WYOMING ESTATES SUBDIVISION

FINAL DRAINAGE REPORT

SEPTEMBER 27, 2019

PCD File No. MS 196

| DRAINAGE PLAN EXISTING CONDITIONS | | |

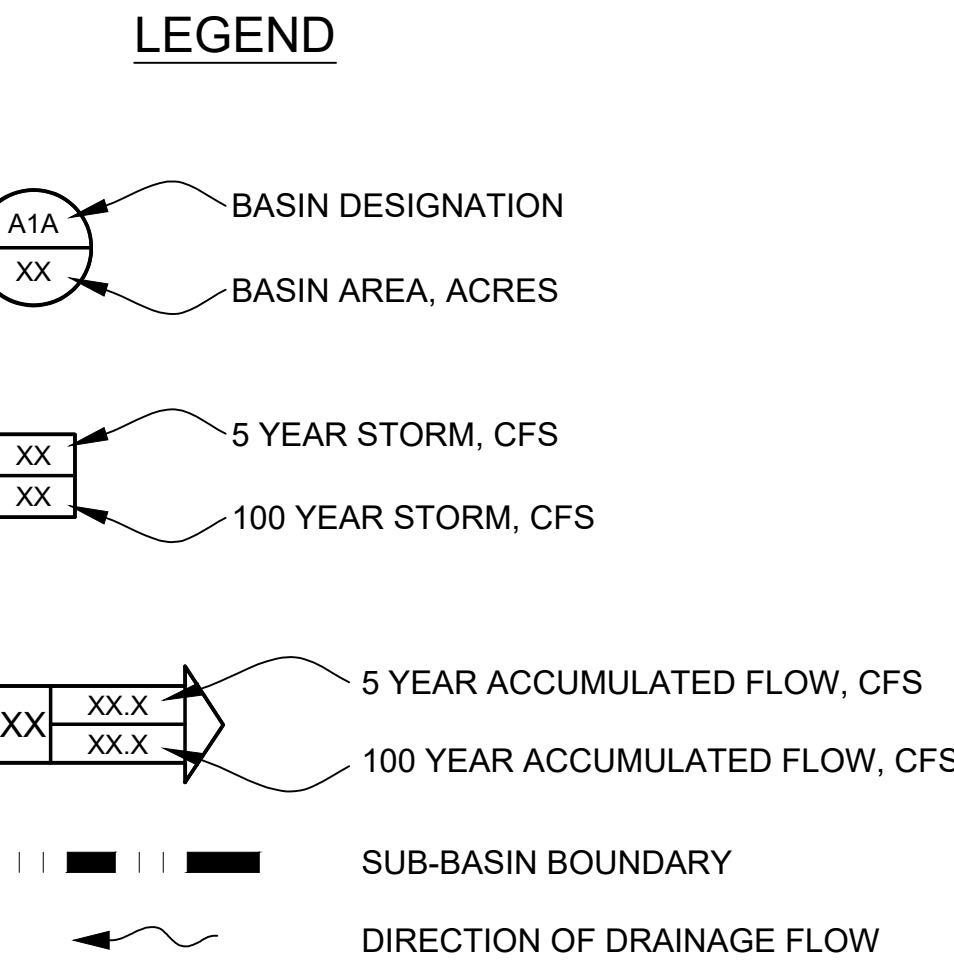
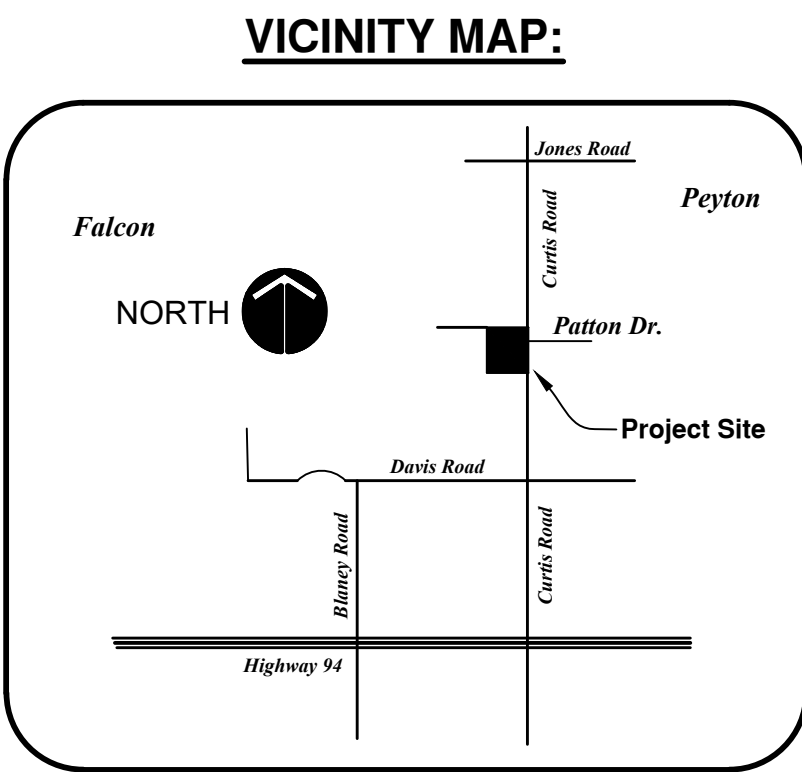
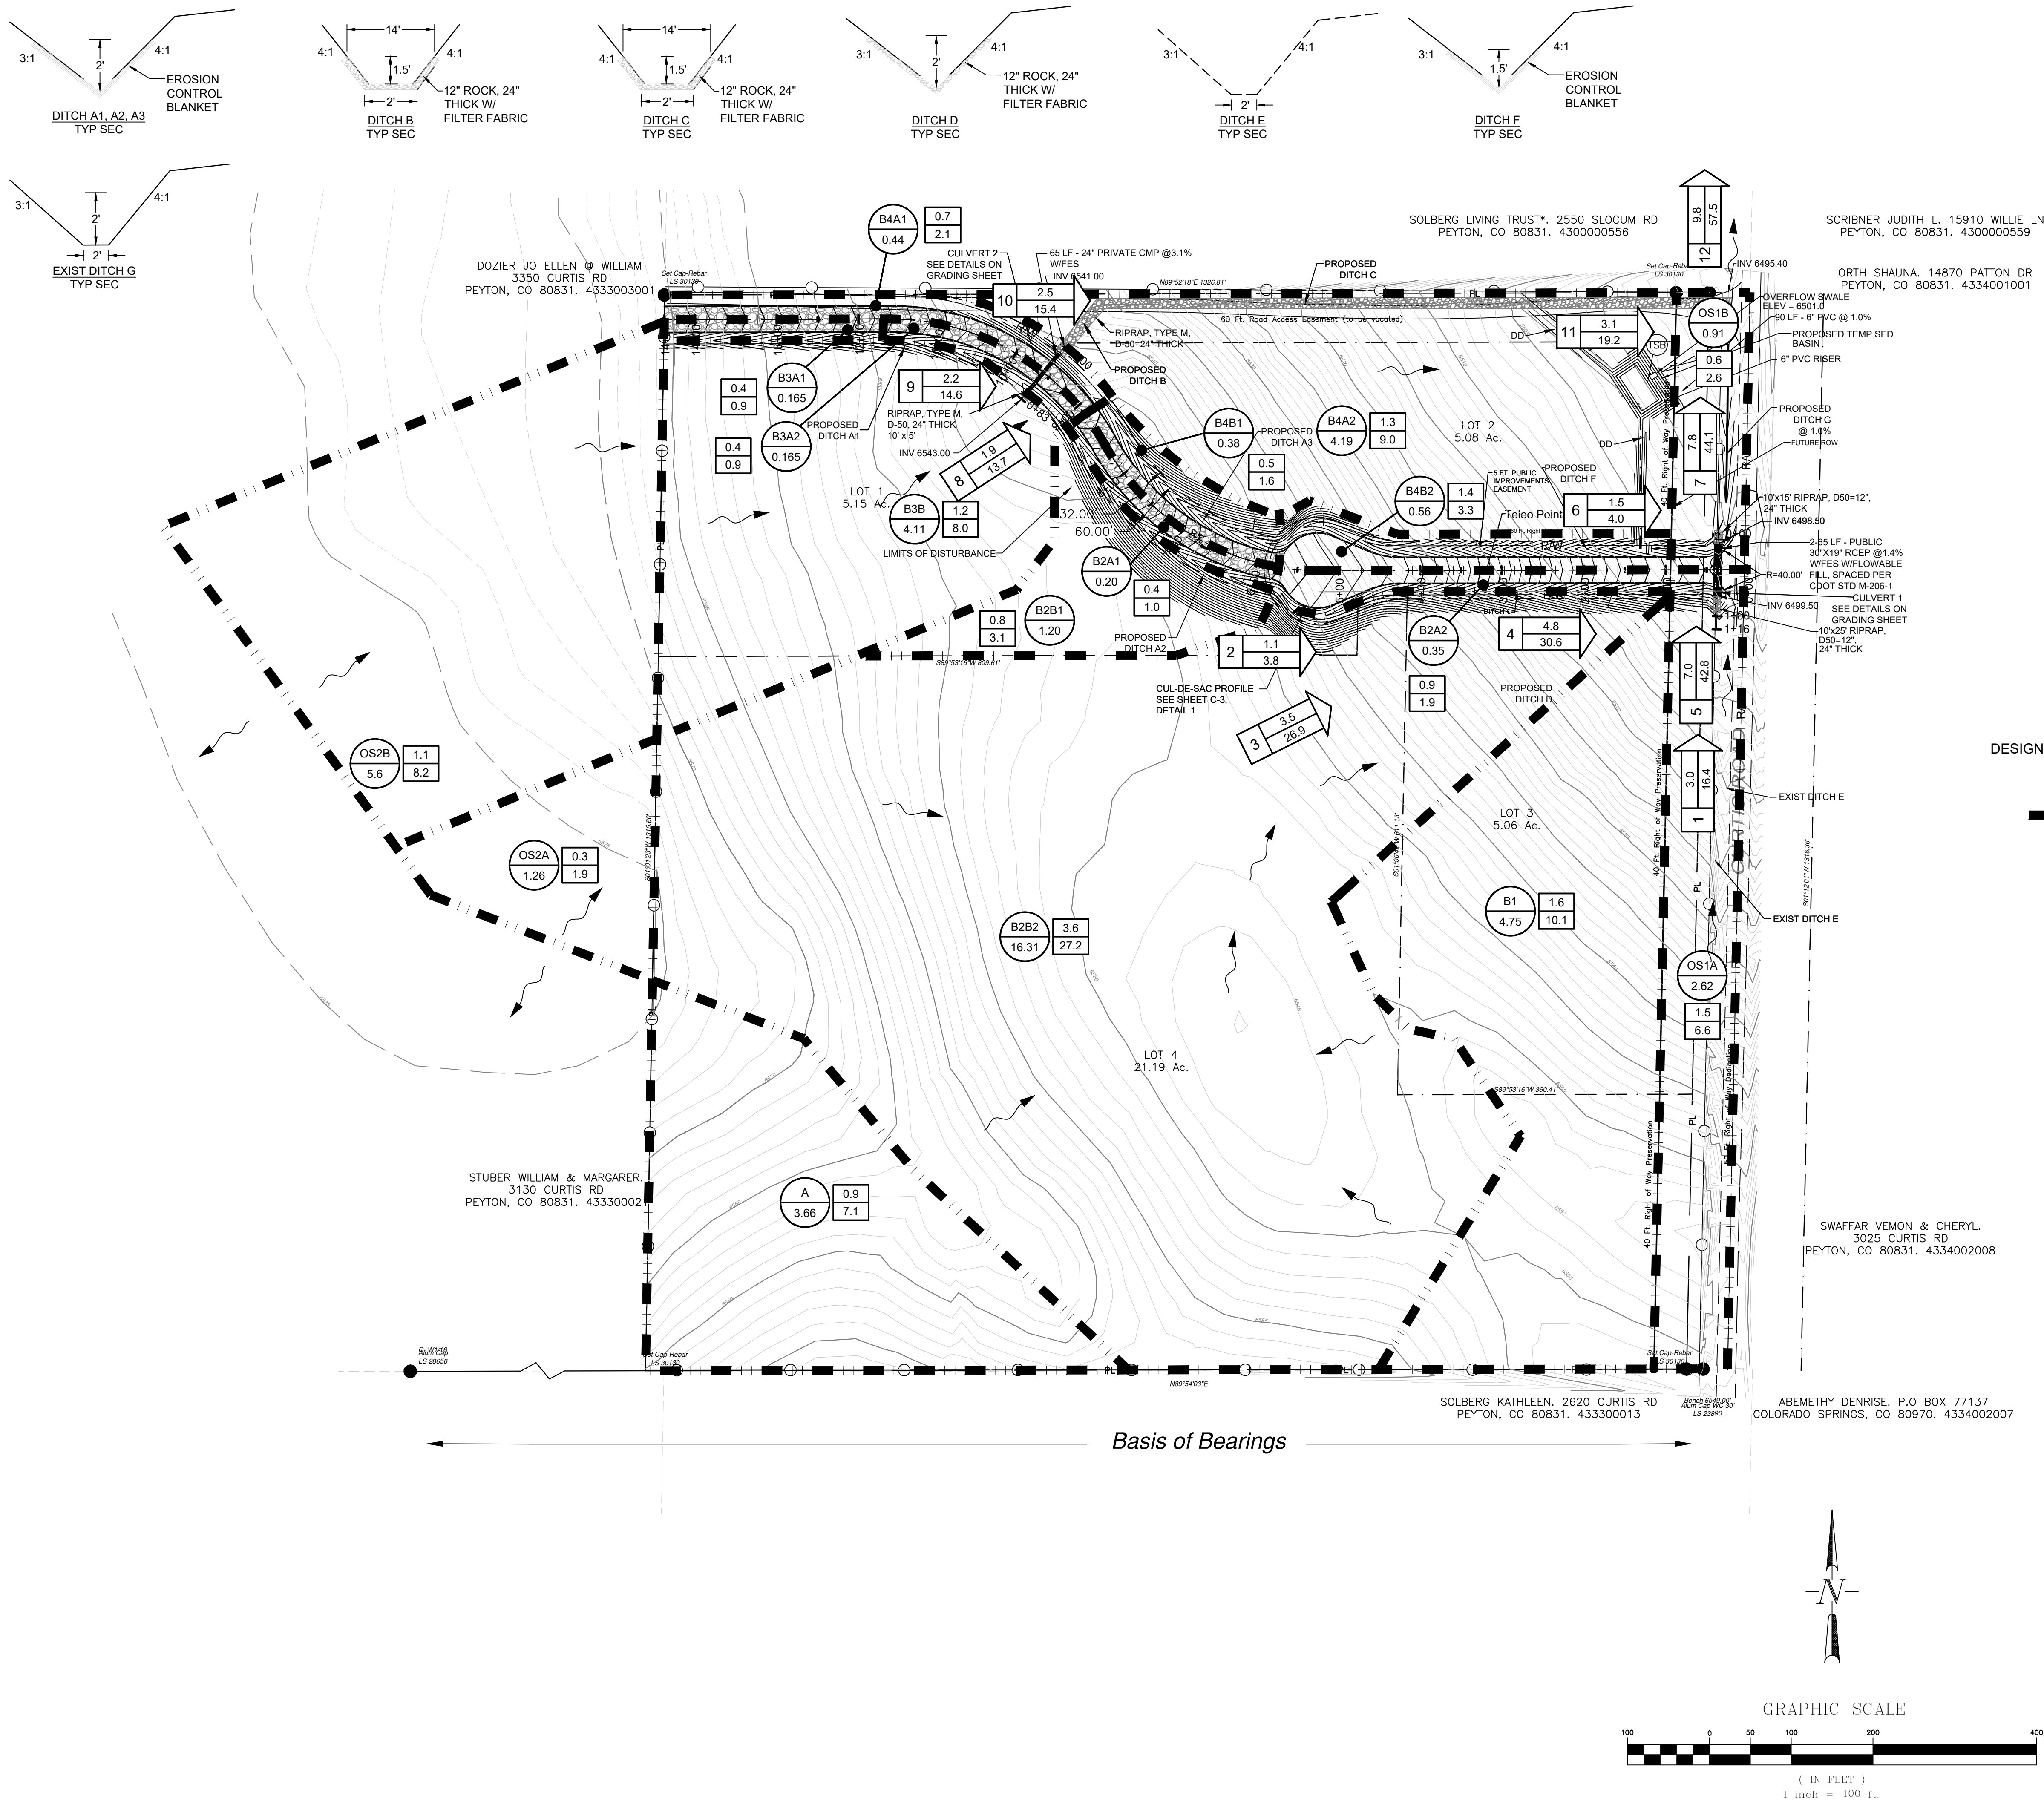
review 1 comment: Shouldn't this be basin B2EX.
review 2: unresolved. It appears that basin OS2 flows into Sub-Basin B2EX as there is no basin B2 in the existing drainage conditions plan. Please revise.

The flow arrows on shown on this page indicate that the majority of the flow is going to the northeast. Revise
